**From:** [Rael, Rudy E.](#)  
**To:** [""Diane Hoelzer" \(Diane@goodwinengineers.com\)""](#)  
**Cc:** [Carrillo, Abiel X.](#)  
**Subject:** 6309 Camino Alto NW  
**Date:** Friday, December 16, 2016 9:01:00 AM  
**Attachments:** [image001.gif](#)

Based upon the information provided in your submittal received 12/12/16, the above referenced Grading and Drainage plan dated 12/9/16 cannot be approved for Grading Permit or Building Permit until the following comments are addressed:

**ROYBAL RESIDENCE**  
**6309 CAMINO ALTO N.W.**  
**GRADING & DRAINAGE PLAN**

ROYBAL RESIDENCE
6309 CAMINO ALTO N.W.
GRADING & DRAINAGE PLAN

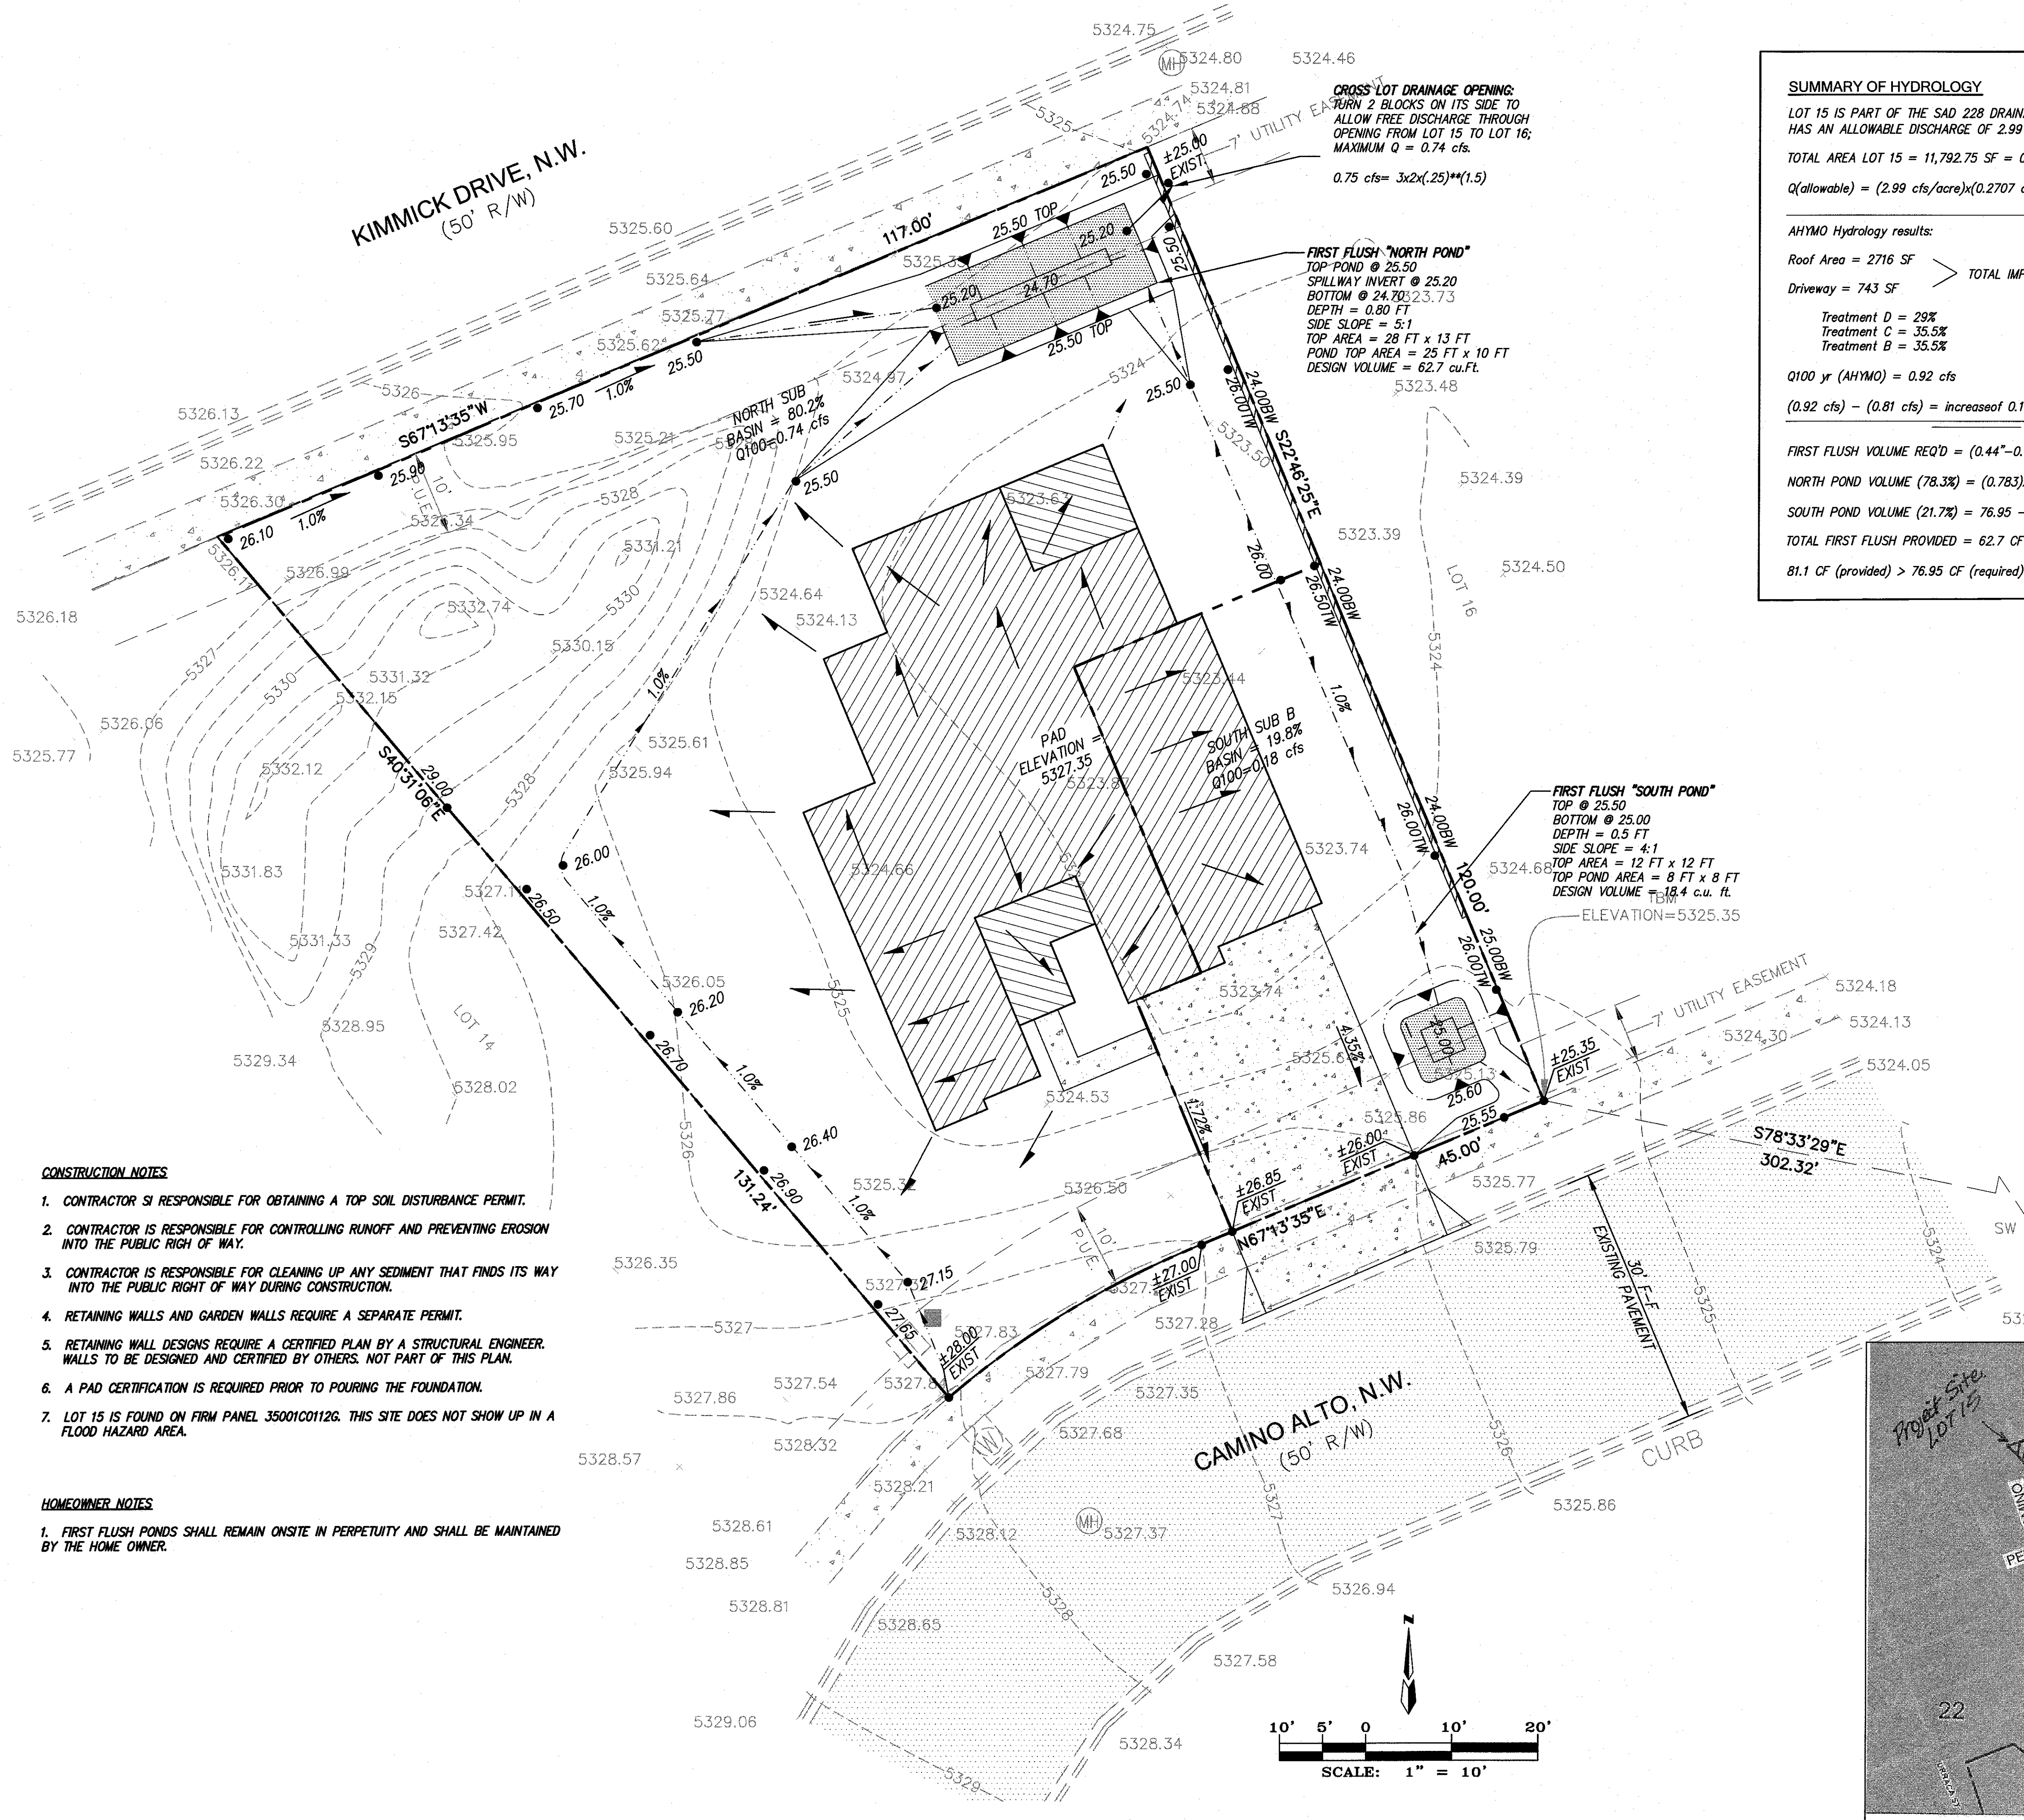
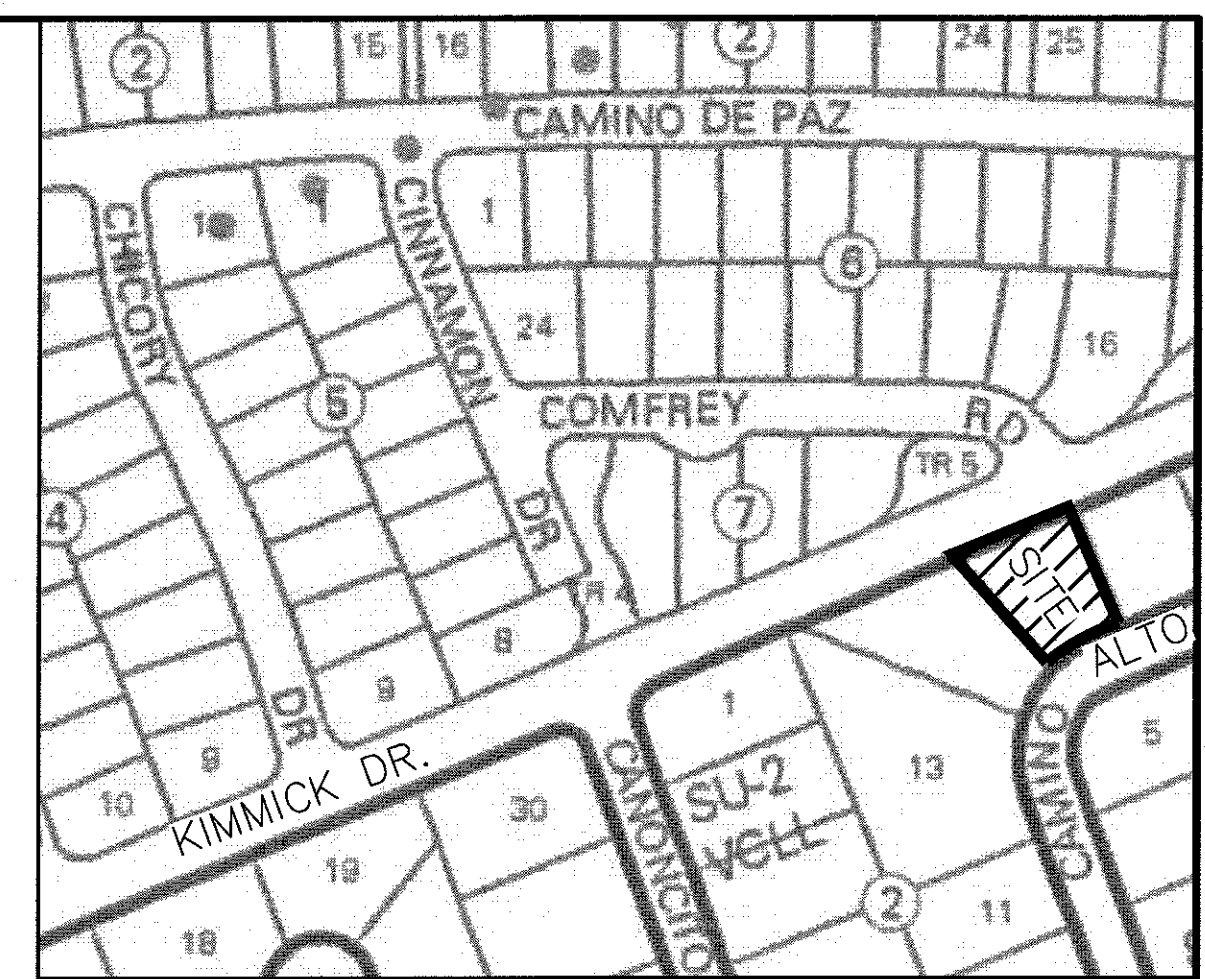
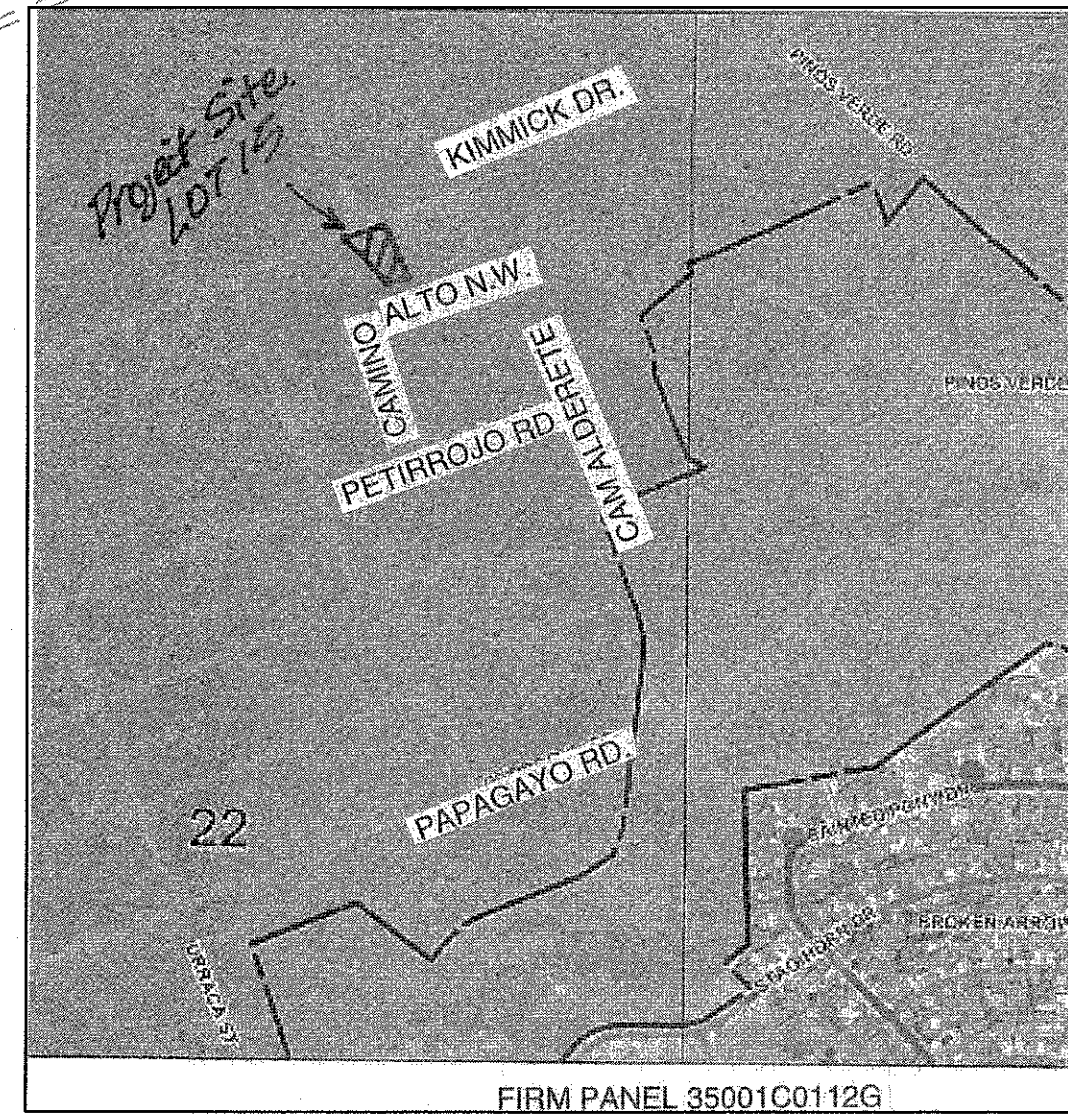
- Provide flows exiting the rear yard, these flows are to enter the existing pond on the west side of Kimmick St.
- Provide the proper size openings in the rear walls for cross lot draining.
- Provide a note on the plans requiring the openings to be 3" above grade.
- Provide a note stating that retaining walls and garden walls require a separate permit. Also let the owner or contractor know that the retaining wall requires an engineer certified plan. If you are not the engineer for the walls provide a note stating that walls are being certified by others.
- Provide a note about the Special Flood Hazard Area (SFHA).
- Provide a note that a Pad Certification is required before pad is poured.
